Application for a non-material amendment following a grant of planning permission.

<input type="text" value="Proposed Two Storey Rear Extension"/>	
Reference number:	<input type="text" value="20/01661/HOU"/>
Date of decision	<input type="text" value="25/03/2021"/>

Reconfiguration of window apertures to East Elevation  
Inclusion of Flue  
Removal of Render material and replacement with facing brickwork at Lower Ground Floor Level

2487-EA-00-00-DR-A-107-B2 - PROPOSED ELEVATIONS

**PROPOSED ELEVATIONS**

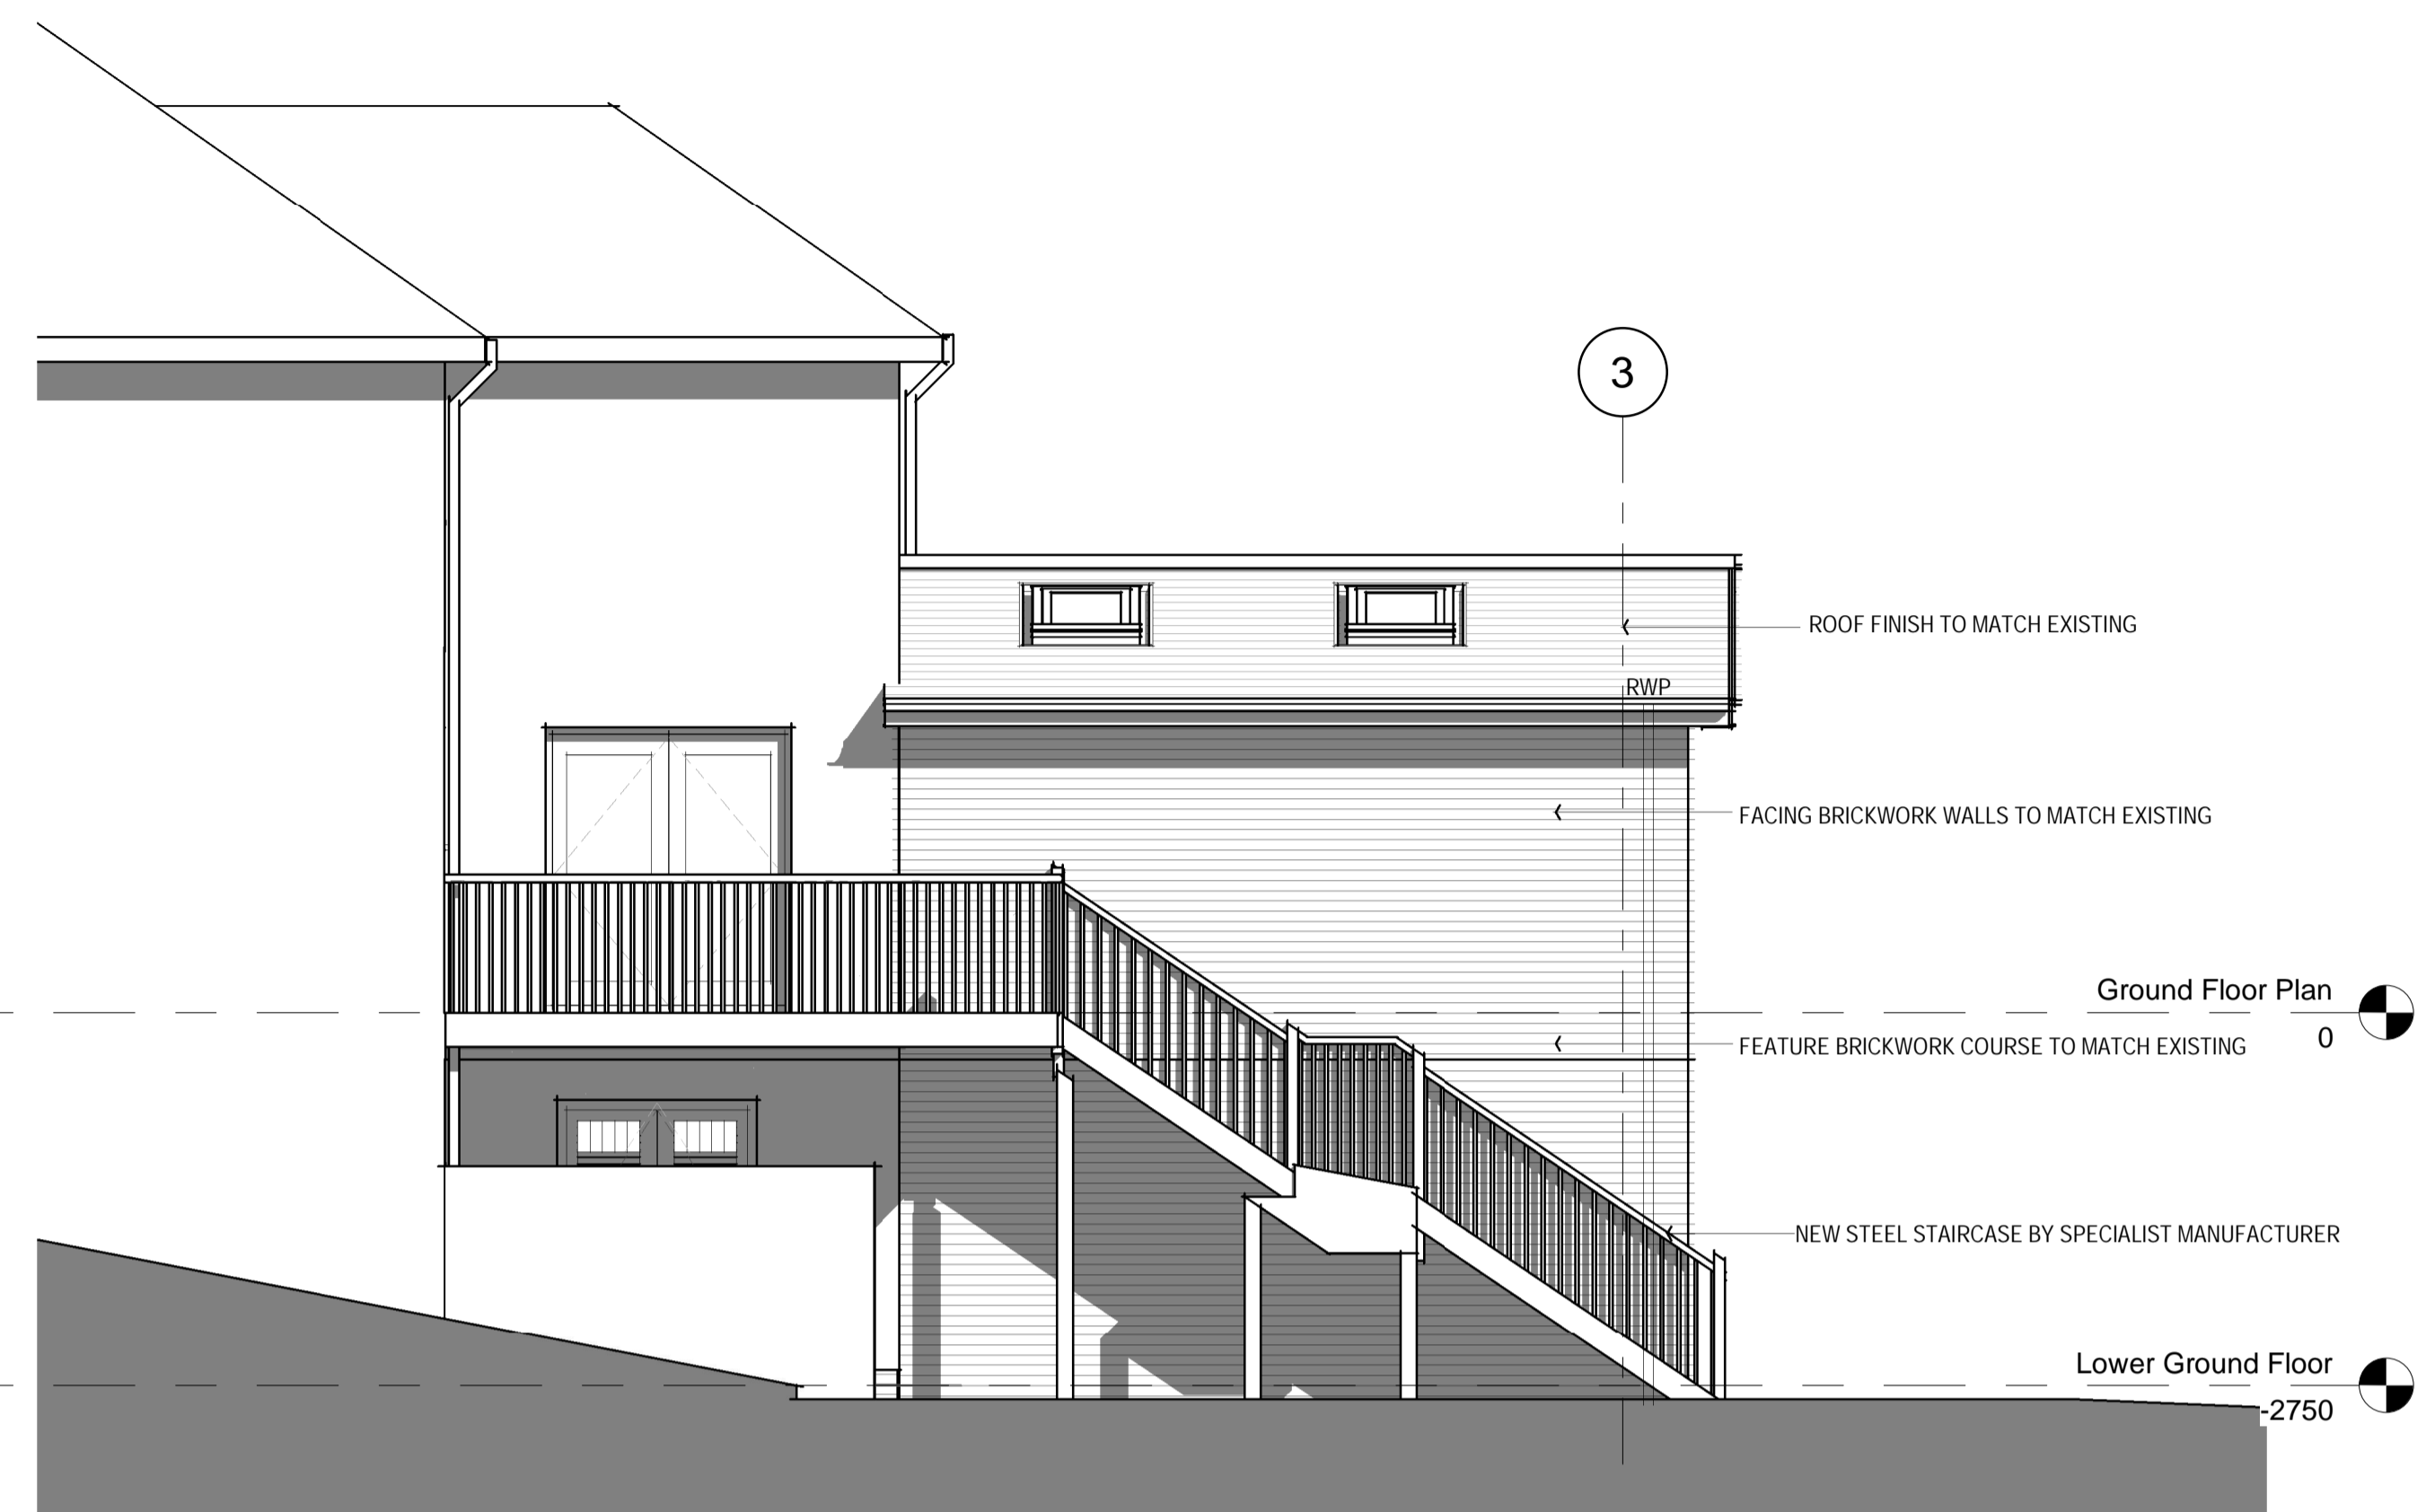
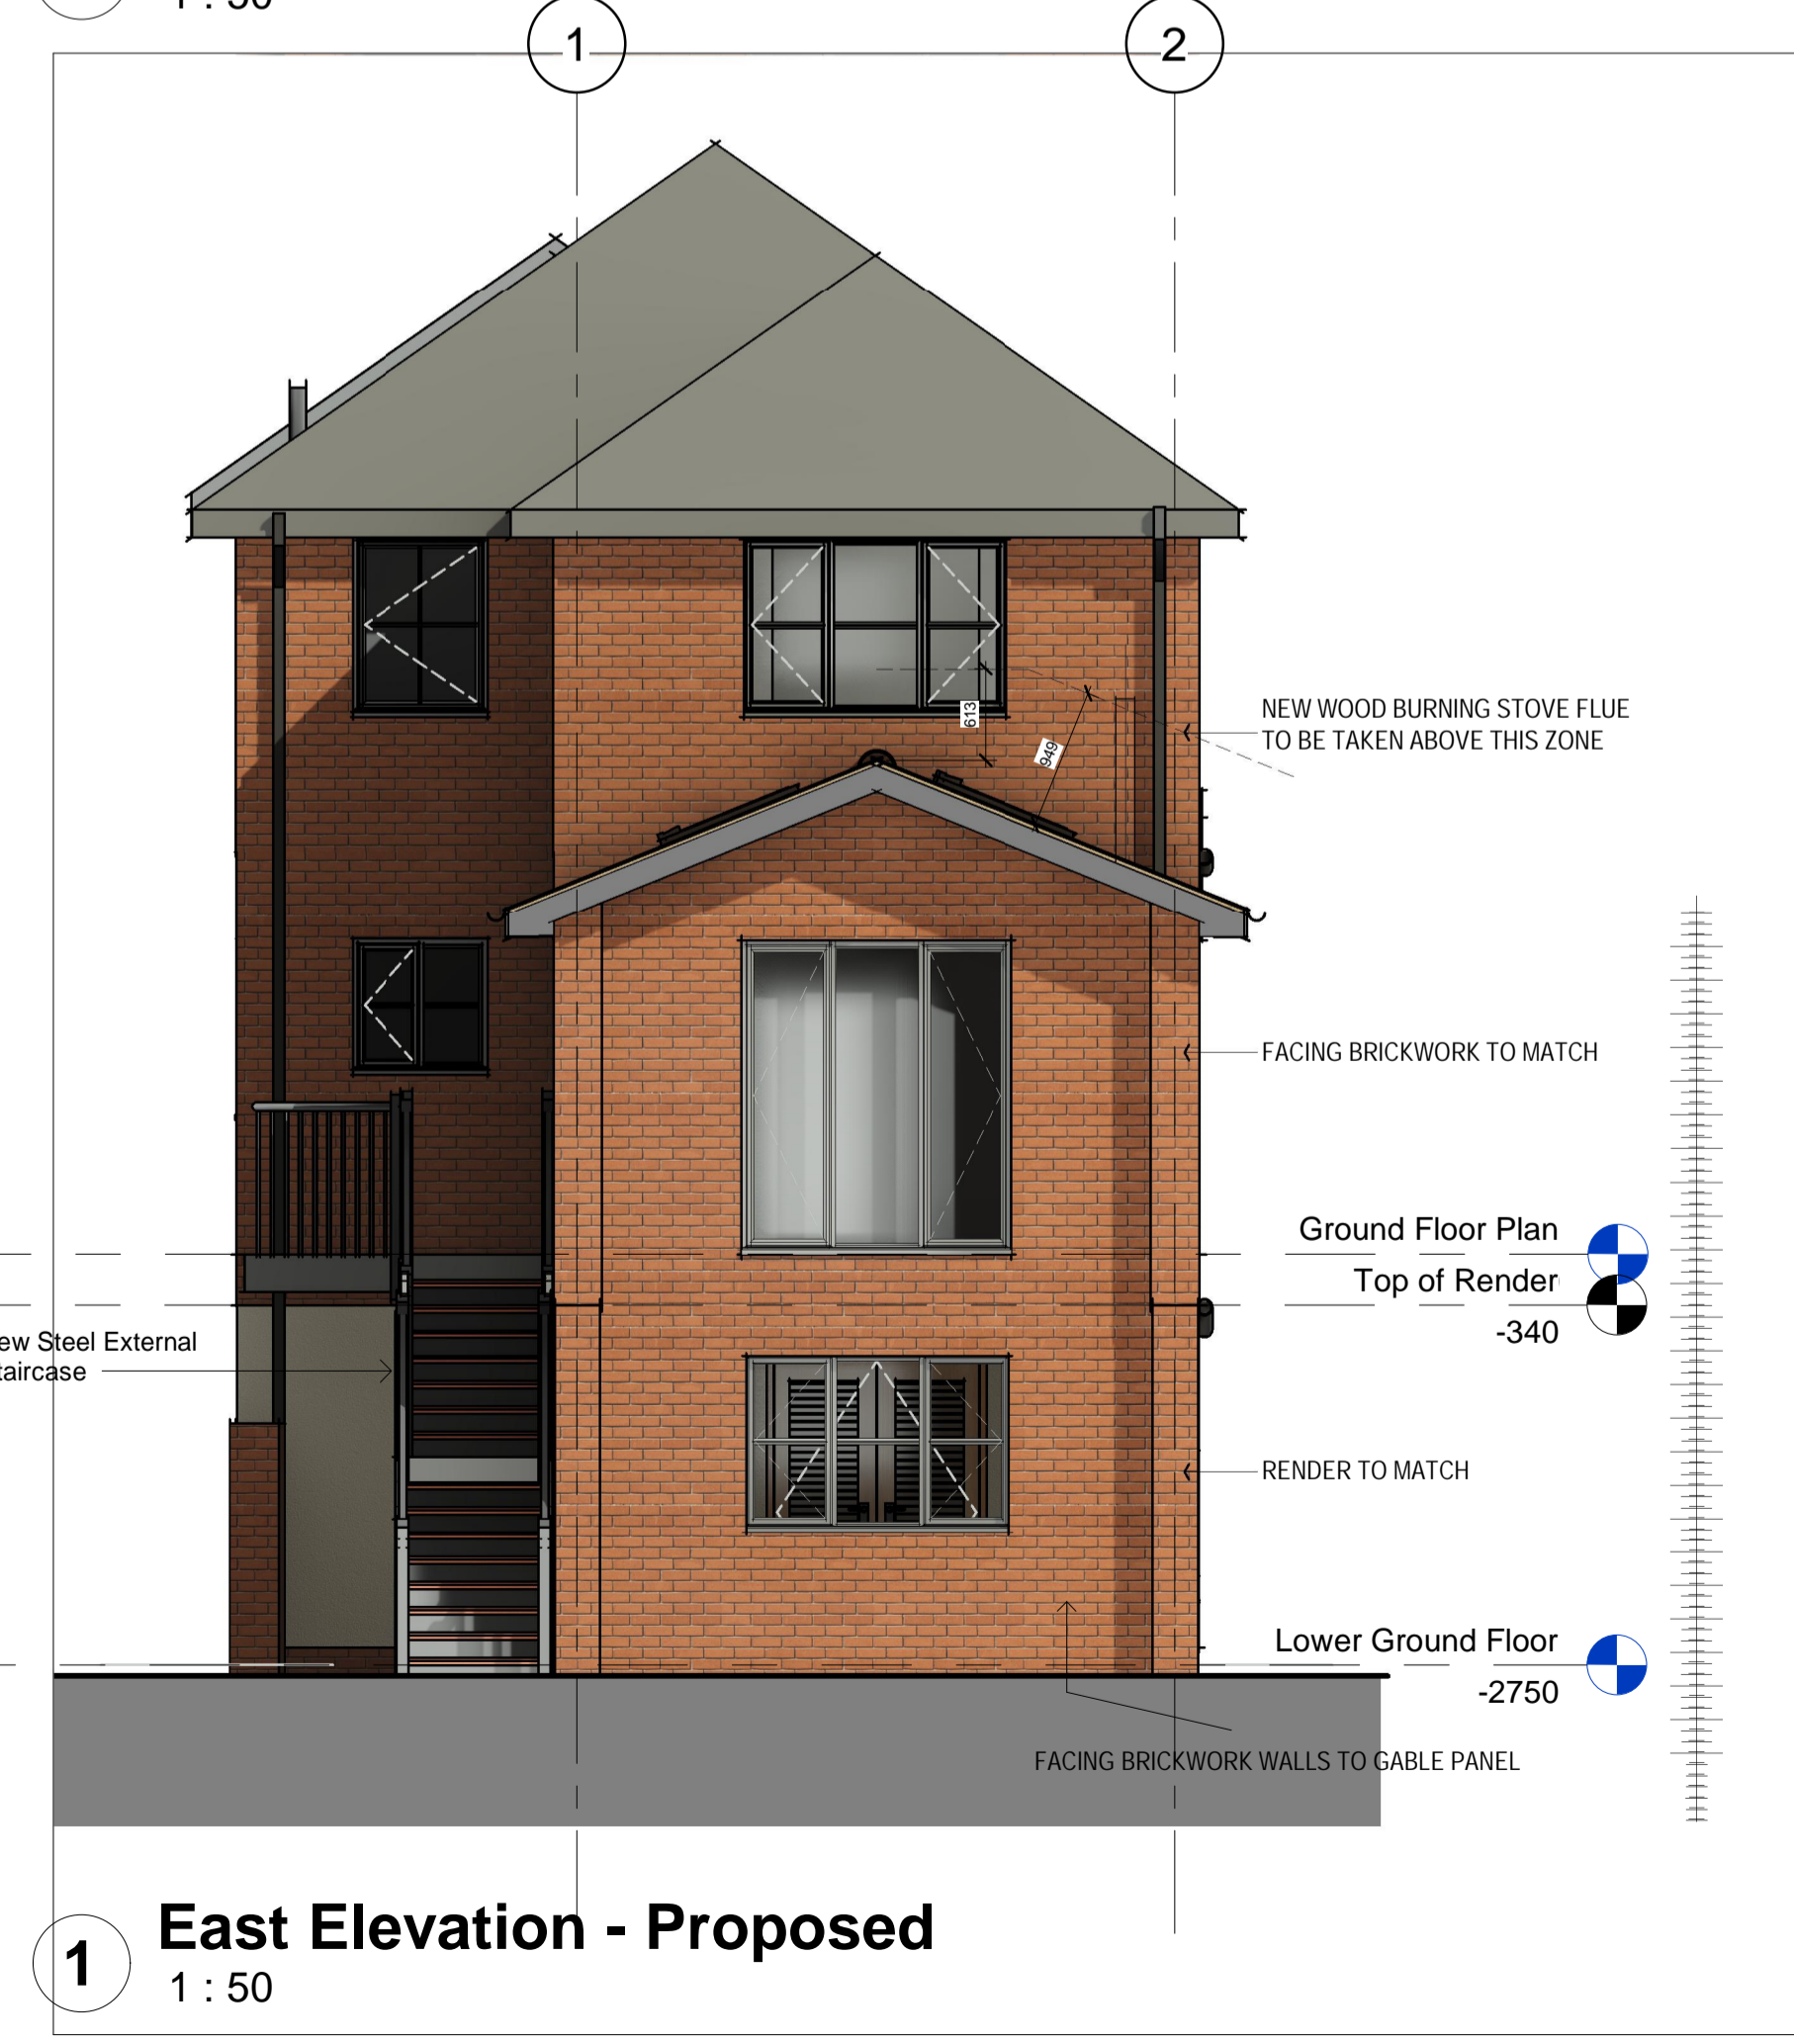
Client wishes to have different window apertures.  
Facing brickwork is a more robust material solution
